State of Washington
DEPARTMENT OF FISH AND WILDLIFE

January 24, 2018

RE: WDFW comments on SP-17-00003 Mitchell Short Plat along the Ferguson Branch of Naneum Creek

NANEUM ROAD SHORT PLAT  
 PART OF SECTION 33, T. 18 N., R. 19 E., W.M.  
 KITTITAS COUNTY, WASHINGTON

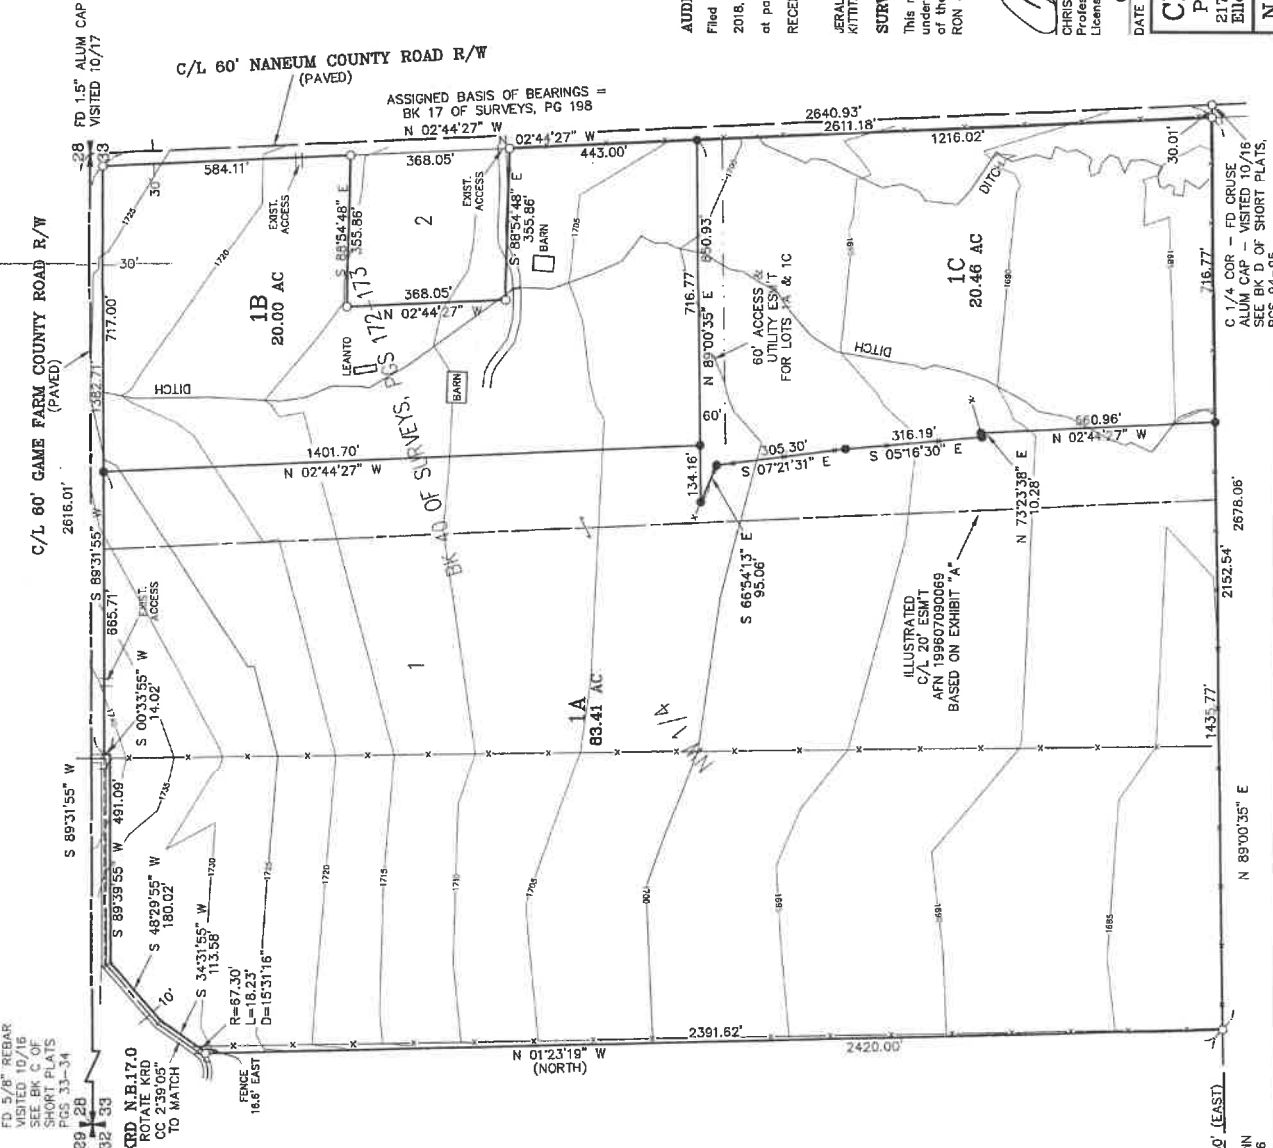
events (see attachment). As currently proposed, parcels 1B and especially 1C look to have extremely limited future buildable areas if proper critical area protections are applied for 1) wetlands, 2) geological hazards (alluvial fans, channel migration zones), 3) frequently flooded areas, or 4) fish and wildlife habitat conservation areas (streams, riparian areas).

As part of the short plat process, future building and septic locations should be considered such that these critical areas can be protected and to protect new infrastructure and help ensure public safety. At least four of five critical areas are likely present on the property that do not seem to be represented in the Master File for this proposed short plat.

We believe lot 1C may not have a future building site that will not be at risk of flood damage and that will protect critical area functions associated with the Ferguson Branch. We recommend a reconfiguration of the proposed lots to ensure a non-buildable lot is not created with this process. Please ensure approval of this short plat will provide adequate protection to the Ferguson Branch and the critical areas associated with it into the future.
